Planning Application No: 3/2025/0194

Proposal: Proposed conversion of garage to form additional living space.

Location: 27 Poplar Way Barrow BB7 9ZN

Highways & Transport
Lancashire County Council

EXISTING AND PROPOSED SITE PLAN.

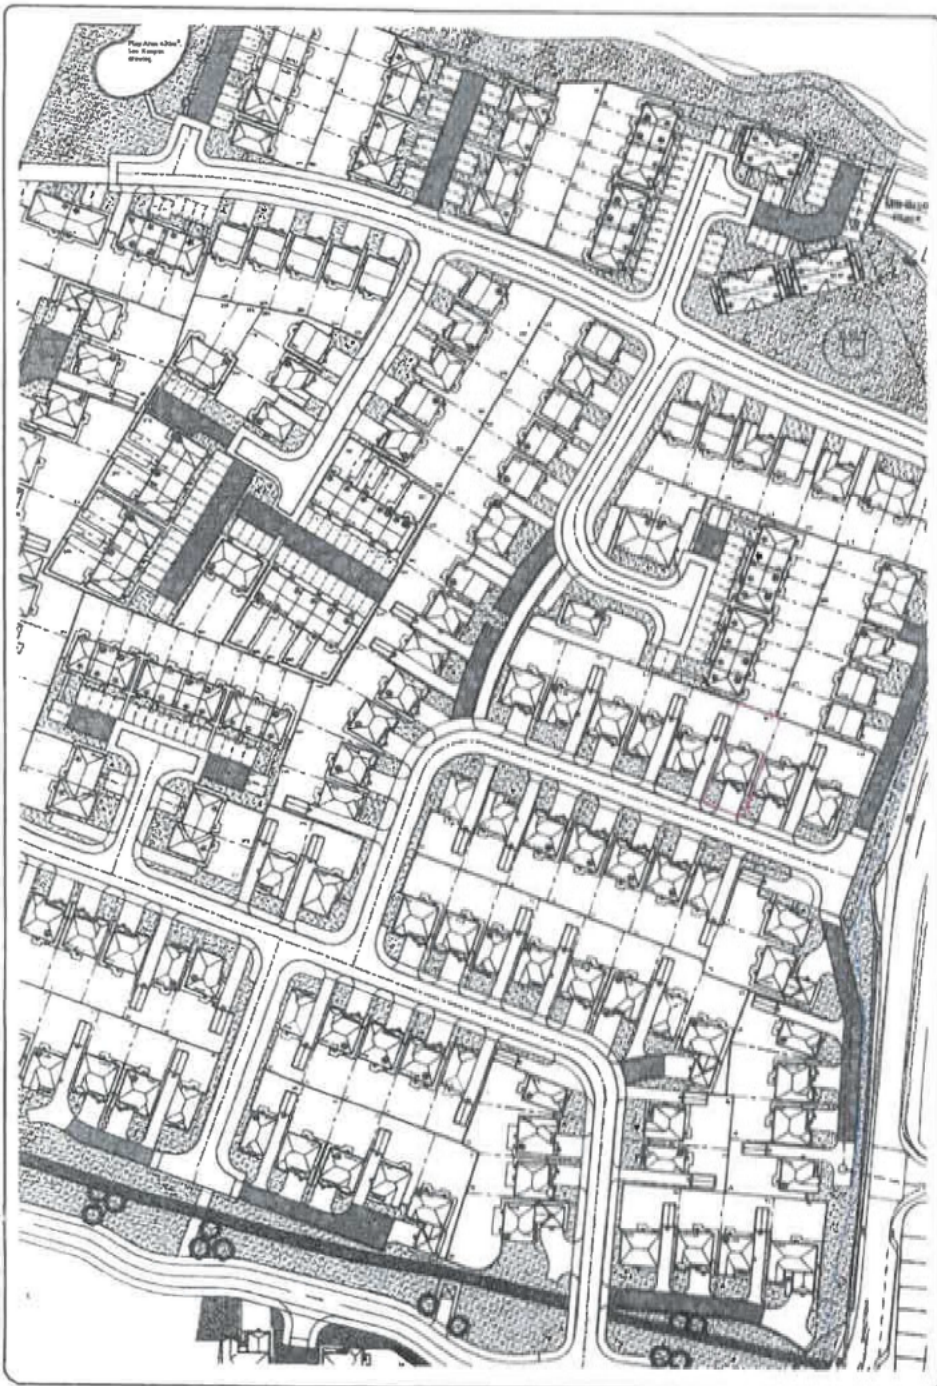
Parking standards require a garage to be 6m x 3m to enable vehicle parking. There is no objection to the proposal as the original garage is substandard (3 x 3.5m). A 4-bedroom dwelling require 3 parking spaces within the curtilage, therefore a shortage of one parking space.
